<b>Your Ref</b>	SSD-48497708
<b>Our Ref</b>	NCA/18/2022
<b>Contact</b>	Paul Sartor
<b>Telephone</b>	9806 5740
<b>Email</b>	<a href="mailto:psartor@cityofparramatta.nsw.gov.au">psartor@cityofparramatta.nsw.gov.au</a>

### **COUNCIL SUBMISSION**

#### **NOTICE OF EXHIBITION OF ENVIRONMENTAL IMPACT STATEMENT FOR THE CONCEPT AND STAGE 1 APPLICATION FOR THE REDEVELOPMENT OF THE KING'S SCHOOL (87-129 PENNANT HILLS ROAD, NORTH PARRAMATTA)**

ASSET PROTECTION ZONE (APZ) - DAY BOY HOUSE	
APZ AREA	2,281m ²
EXISTING CANOPY COVER	1,850m ² (81%)
EXISTING CANOPY COVER (ADJUSTED FOR AVERAGE CROWN DENSITY OF 80%)	1,480m ² (65%)
FUTURE CANOPY COVER	436m ² (19%)
FUTURE CANOPY COVER (ADJUSTED FOR AVERAGE CROWN DENSITY OF 80%)	349m ² (15%)

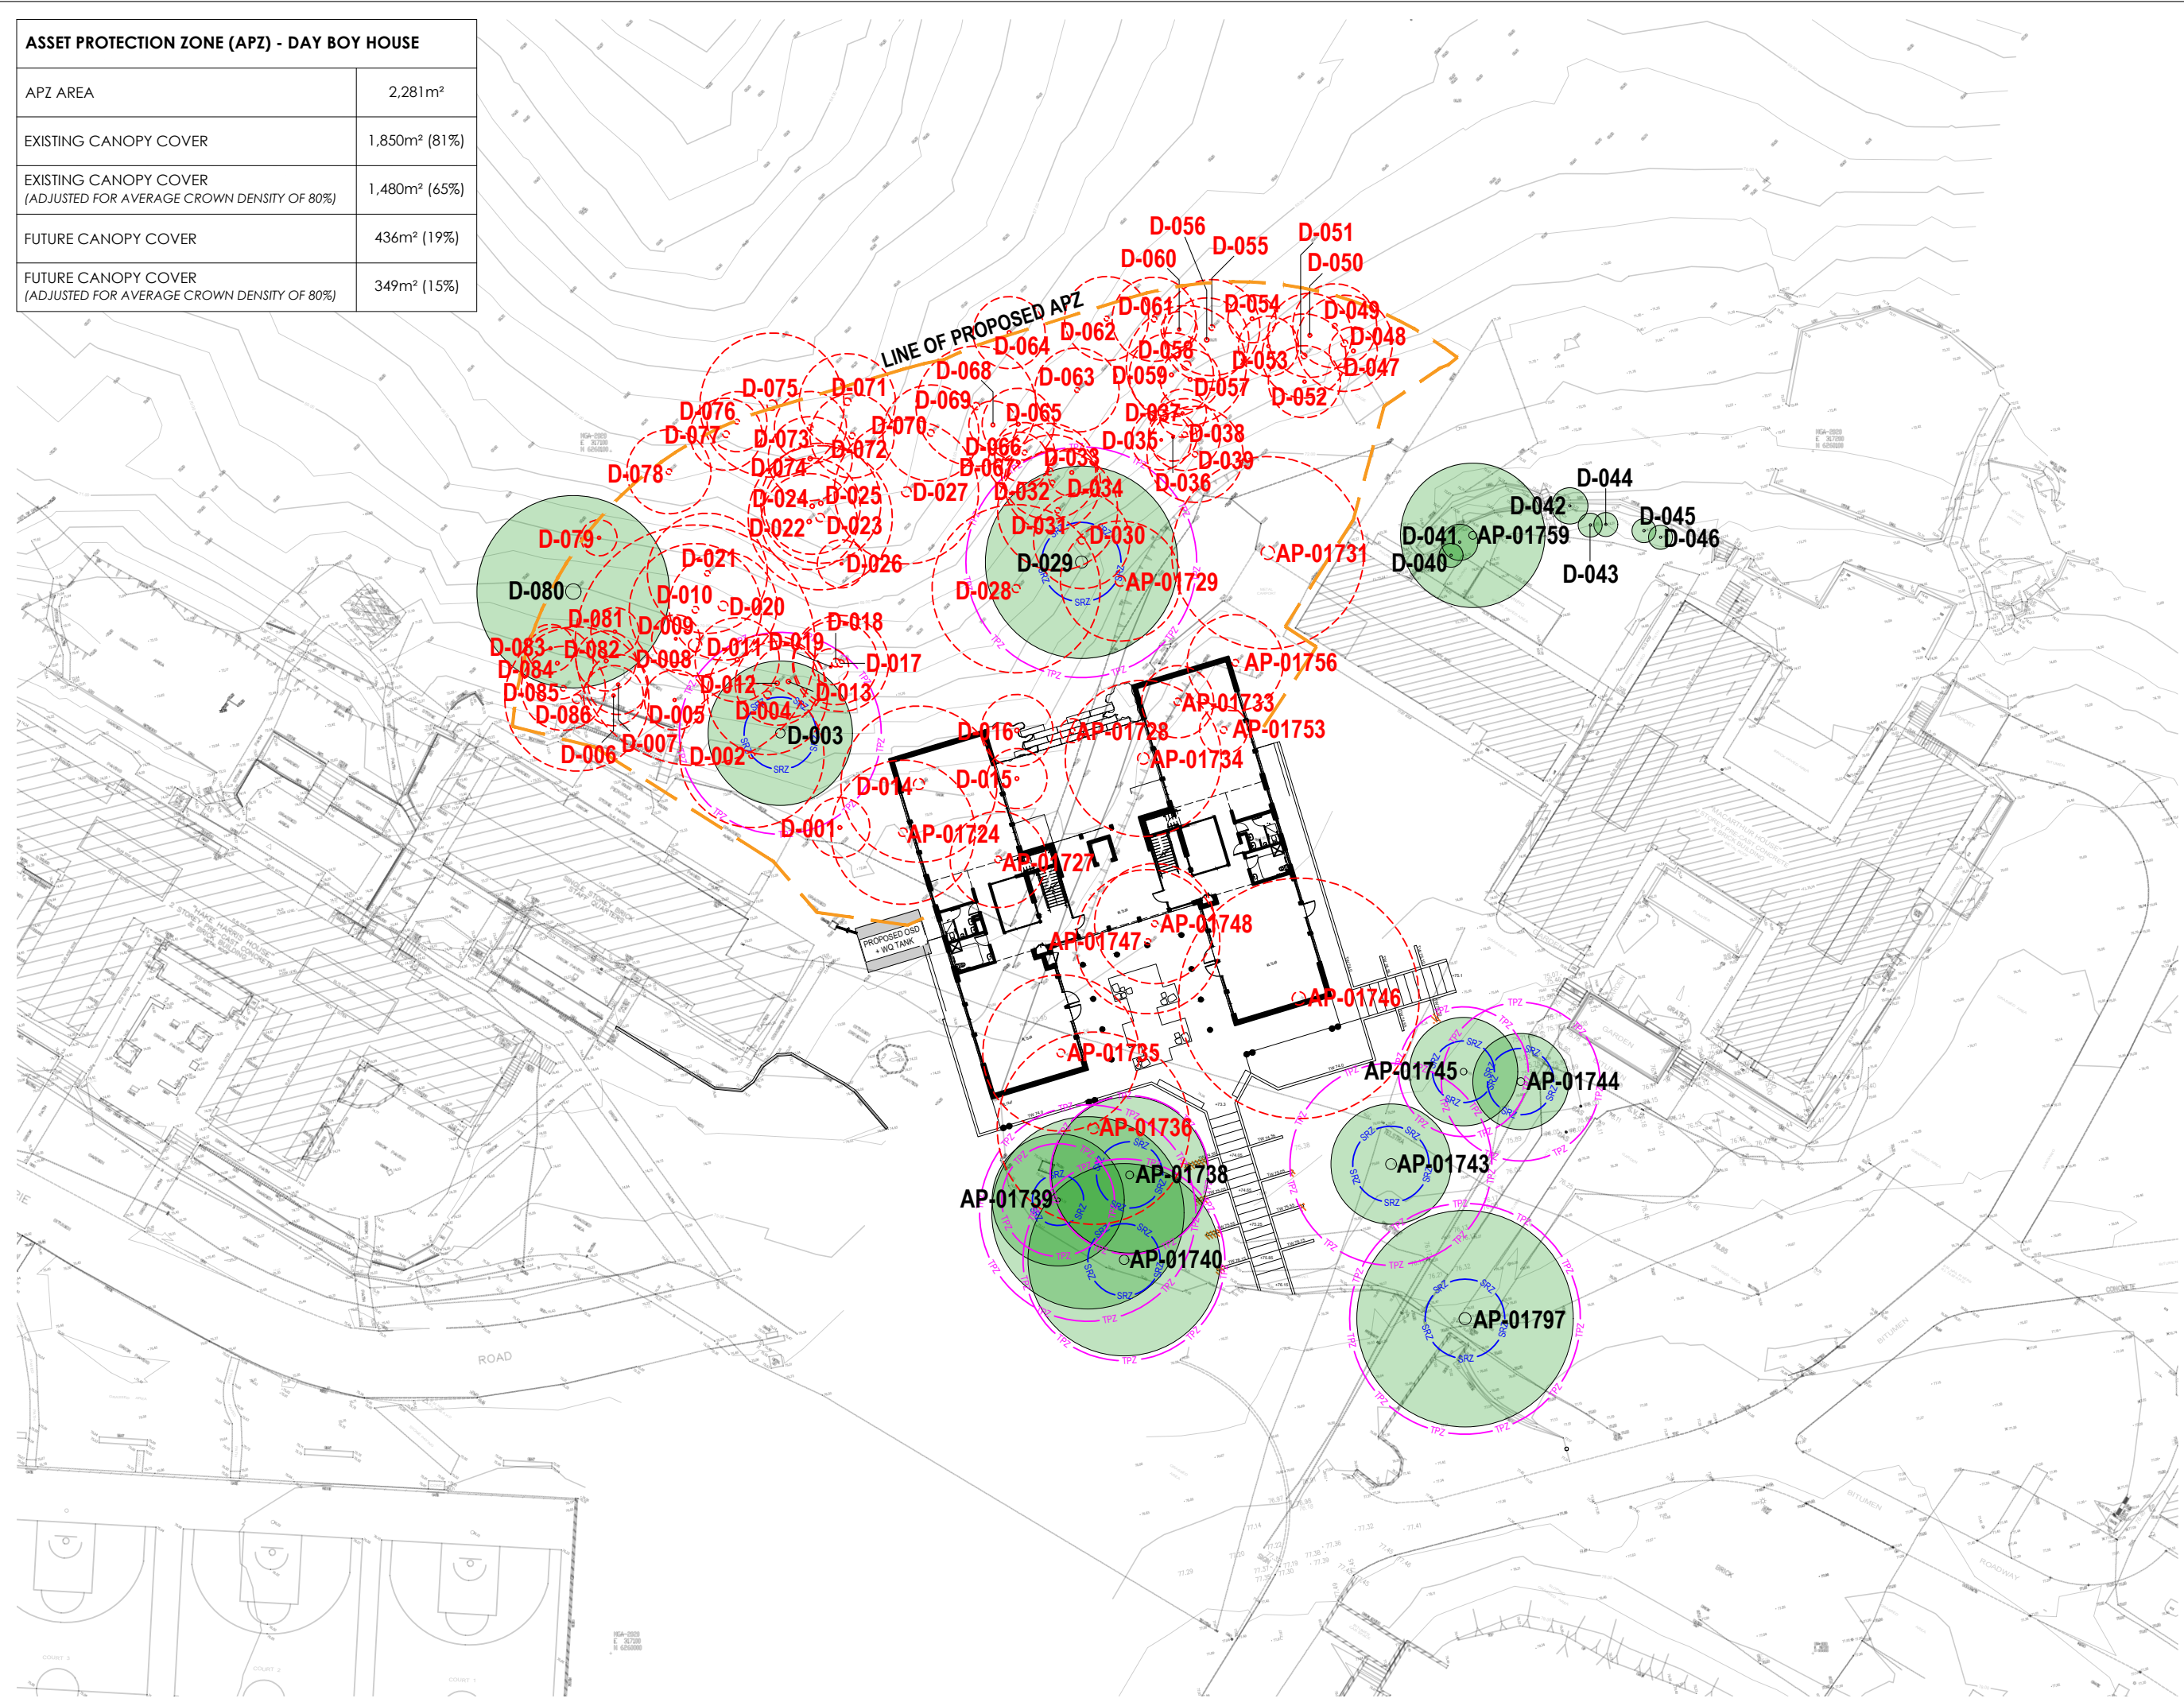
Councils' preference is that building locations are revised to minimise impacts to vegetation with high biodiversity values and habitat for threatened species. This is especially relevant for the Day Boy House and the Boarding House which require the largest tree removal with a biodiversity protection. The relocation of these buildings could also protect the native flora and fauna within the Critically Endangered Ecological Communities natural asset. The BDAR should be updated to demonstrate how impacts were meaningfully avoided/minimised.

Further it is unclear why some trees are shown to be removed outside the APZ (for example B154, B242, B225, B265, B260, B182). Extra detail is requested on why some trees are shown to be removed within the APZ and others retained. Based on clearing trees to separate the crowns by 2 – 5m to reduce the canopy cover as per the bushfire clearing requirements, it would appear many trees can easily be retained, especially since it is noted in the tree schedules that some are significant trees without any defects and which have enough separation from the ones shown to be retained (for example D075, D048, D061, B033, B122, B189, B073, B184, B140).
